Rezoning Transportation Analysis
Petition Number: Insert Zoning Petition #2021-201
General Location Identifier: Tax ID 12709305

Revision Log:

Date	Description
12-23-21	First Review (WB)
02-21-21	Second Review (WB)
04-25-22	Third Review (WB)

SHEET NAME
REZONING SITE PLAN

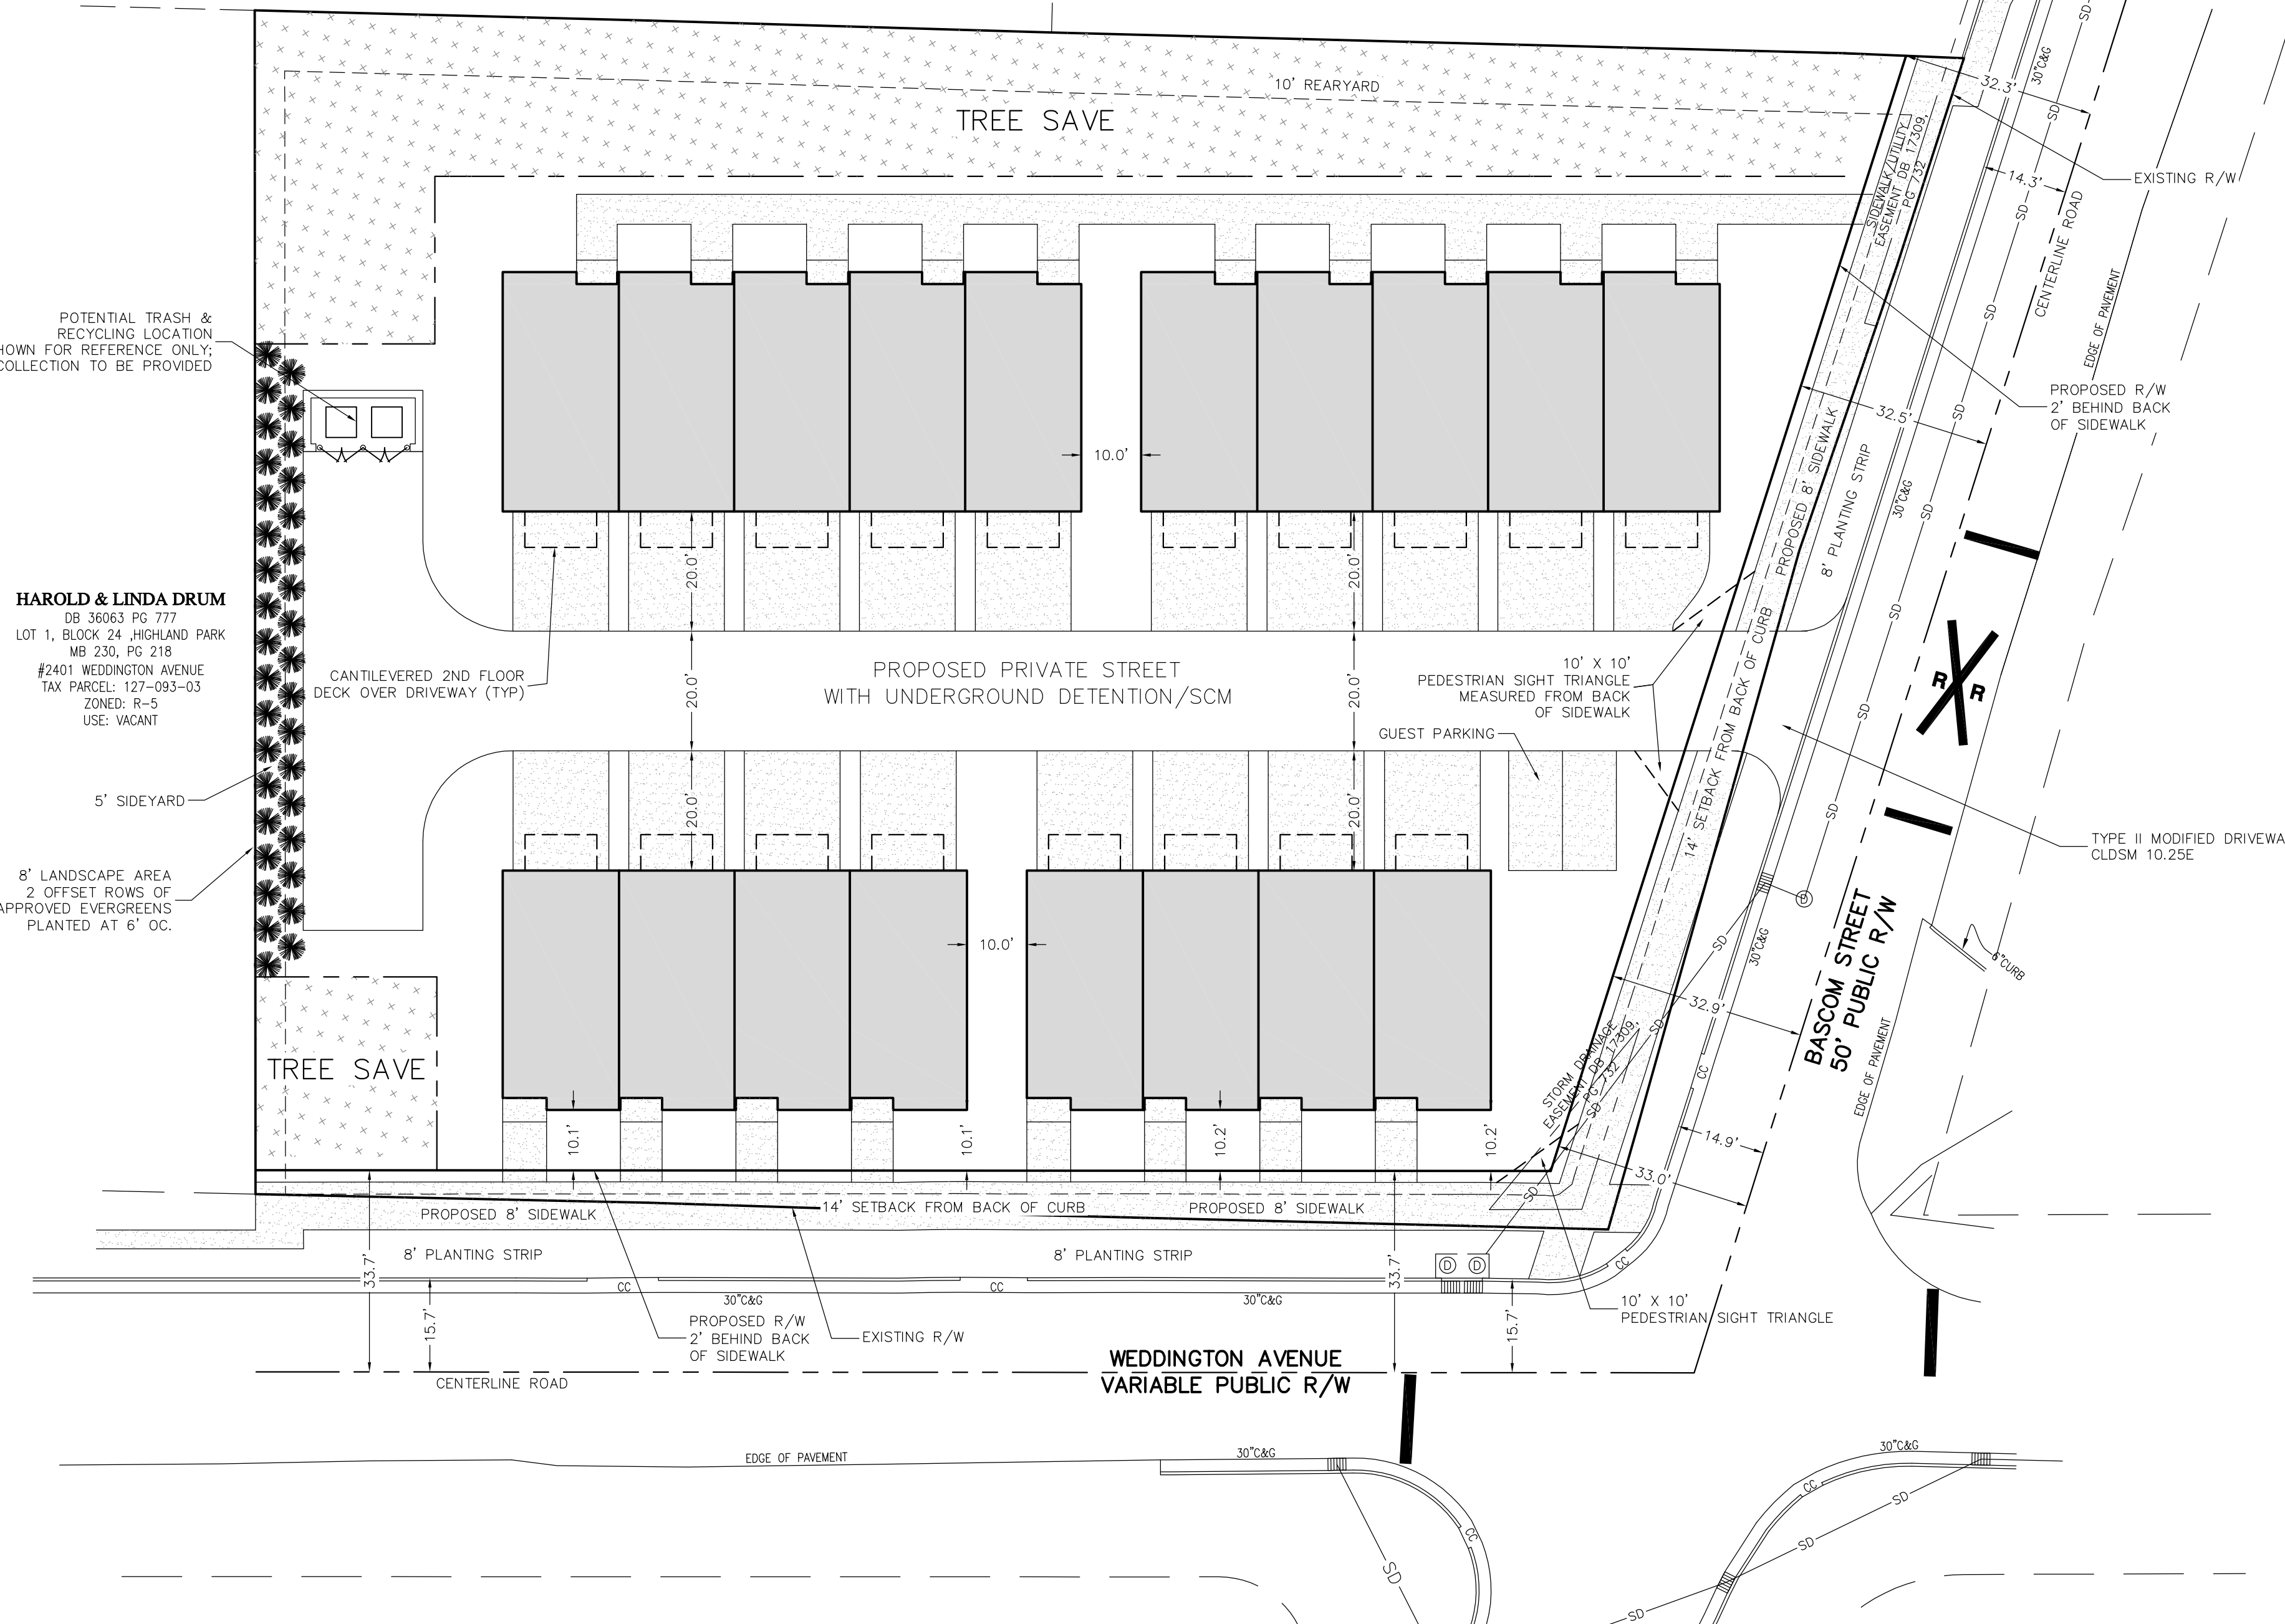
1. ~~Curbline:~~ The proposed zoning district has a setback measured from back of the existing or proposed future curbline.
 - a. ~~Weddington Avenue:~~ The curb line will remain in its current location.
 - b. ~~Bascom Street:~~ The curb line will remain in its current location.

~~Label and dimension the curb and gutter from the centerline for each road on the site plan.~~

3. **Comment Rescinded** (Weddington Ave along the site’s frontage no longer functions as a Collector. Referenced correspondence with CDOT P&D on 3/14/2022): ~~Revise site plan and conditional notes to commit to dedicate a 36-foot right-of-way from the road centerline on Weddington Avenue and Bascom Street. The site plan shall label and dimension the right-of-way from the road centerline.~~

4. ~~The proposed dwelling units exceeds 12 dwellings per acre. Per Chapter 20, Subdivision ordinance, site plan and conditional notes revisions are needed to commit to construct an 8-foot planting strip, and 8-foot sidewalk along both Collector Roads. The wider sidewalk also meets the Charlotte WALKS Policy.~~

~~Reference (CLDSM standard detail U-07) for street typical.~~

5. ~~Site plan and conditional notes revisions are needed to provide 10’ x 10’ pedestrian sight distance easements for any portion of the pedestrian sight triangles located outside the right of way and within the development. Remove proposed driveway from the pedestrian sight triangle. The pedestrian triangle measures 10 feet x 10 feet with one leg measured along the back of sidewalk or right of way (whichever is the greater distance from the curb line) and the other leg measured along the driveway face of curb or edge of pavement. Also provide Pedestrian sight triangles at the intersection of Weddington avenue and Bascom Street.~~

6. ~~Site plan revisions are needed to construct a CDOT standard driveway per CLDSM 10.25E. Proposed radii must match the City standards.~~

7. ~~Revise Site plan to construct two (2) accessible curb ramps at the intersection per PROWAG and ADA law.~~

- ~~8. Add a site plan note specifying dedication and fee simple conveyance of all rights-of-way to the City before the site's first building certificate of occupancy is issued. CDOT requests rights-of-way set at 2-feet behind back of sidewalk where feasible.~~
- ~~9. Add a site plan note specifying that all transportation improvements will be approved and constructed before the site's first building certificate of occupancy is issued. The petitioner may phase transportation improvements if said improvements and phasing are explicitly described in site plan notes.~~
